**KIRKLEES METROPOLITAN COUNCIL
INVESTMENT & REGENERATION SERVICE**

DELEGATED DECISION TO DETERMINE PLANNING APPLICATIONS

Reference No:	2024/62/91425/W
Site Address:	2, Kaffir Road, Edgerton, Huddersfield, HD2 2AN
Description:	Erection of extensions and alterations (within a Conservation Area)
Recommending Officer:	Joanna Rednall

DECISION – REFUSED

1 South as Proposed
 1:100

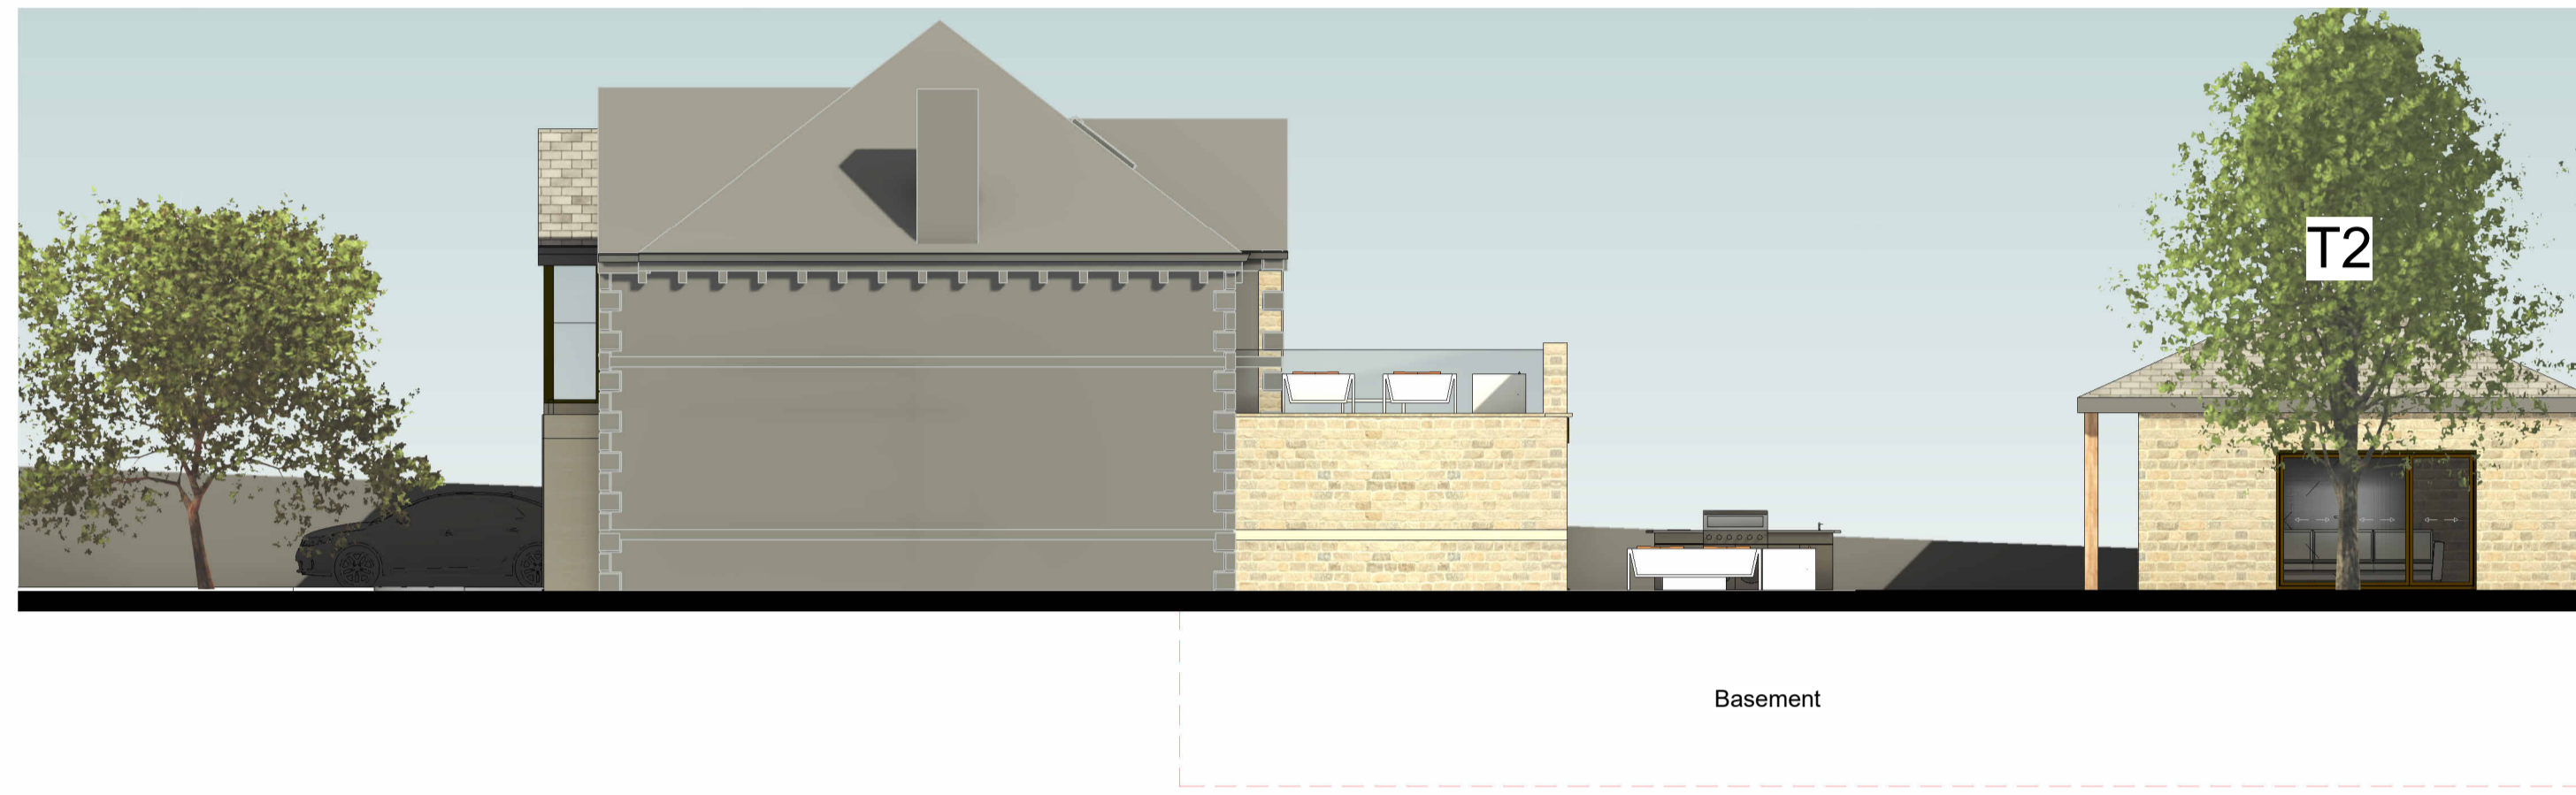
In this context, preservation means not harming the interest of the building itself, or the wider conservation area within which it is set. KC Conservation and Design have been informally consulted during the course of this application and, while they are comfortable with the majority of the works, including the rear and basement extension, rear terrace, front dormer and bay window extensions, concerns have been raised surrounding the degree of glazing proposed to the first-floor front elevation. This is because the extent of glazing proposed to the extension would not appear to be visually subservient and would alter the character of the property and its traditional form. The application property occupies a prominent position within the locality, and the front elevation of the first floor would be elevated above boundary treatment when viewed from public vantage points down Kaffir Road. As such, the insertion of the extent of glazing proposed would appear particularly obtrusive and imposing within the street scene.

The applicant's agent has highlighted that the current dwelling includes two glazed balcony doors at first-floor level, which the applicant's agent notes offers a comparable level of glazing to what is being proposed. However, officer's have assessed that the existing balcony doors are set well back from the front elevation of the host property, and the glazing proposed under this application projects forward of these existing balcony doors and also protrudes forward from the first-floor front elevation. As a result, this would heighten the visibility and prominence of the glazed feature on the original dwelling and would form an incongruous feature within the setting of the Conservation Area. Therefore, it is considered the extent of first-floor glazing would alter the host's traditional form and would not appear visually subservient to the original house and is not considered to sensitively contribute to the character and appearance of the Conservation Area. This would be contrary to Policy LP35 which seeks to ensure that proposals within Conservation Areas conserve those elements which contribute to significance.

Turning to design, it has been assessed the fenestration details to the two-storey extension would not have an acceptable impact upon the host's traditional form and is not considered to sensitively contribute to the character and appearance of the Conservation Area and would therefore have an acceptable impact upon visual amenity. The proposed fenestration details to the ground floor would appear less prominent in the street due to their smaller scale and existing boundary treatments, would not cause harm to the setting of the Conservation Area. Due to these reasons, the proposed development would be contrary to Key Design Principles 1 and 2 of the SPD, Policies LP24 (a and c) and LP35 of the Kirklees Local Plan, and Chapters 12 and 16 of the NPPF.

It is therefore concluded that the development, by virtue of the extent of glazing and fenestration details of the extension to front, would not be subservient to the host building and would introduce an overly modern feature which would diminish the character of the dwelling given the prominence of this element of the proposal in relation to being visible from public vantage points. This would be to the detriment of the host dwelling, wider street scene and the character and appearance of the Edgerton Conservation Area contrary to Key Design Principles 1 and 2 of the SPD, Policies LP24 and LP35 of the Kirklees Local Plan, and Chapters 12 and 16 of the NPPF.

1. The two-storey front extension, by virtue of its design and prominent location, has a harmful impact upon the historic character of the host property and Edgerton Conservation Area. The two-storey front extension constitutes a visually harmful addition which does not respect or enhance the character of the townscape or designated heritage assets. There are no public benefits identified or considered to exist more generally which justify the identified harm to the setting and
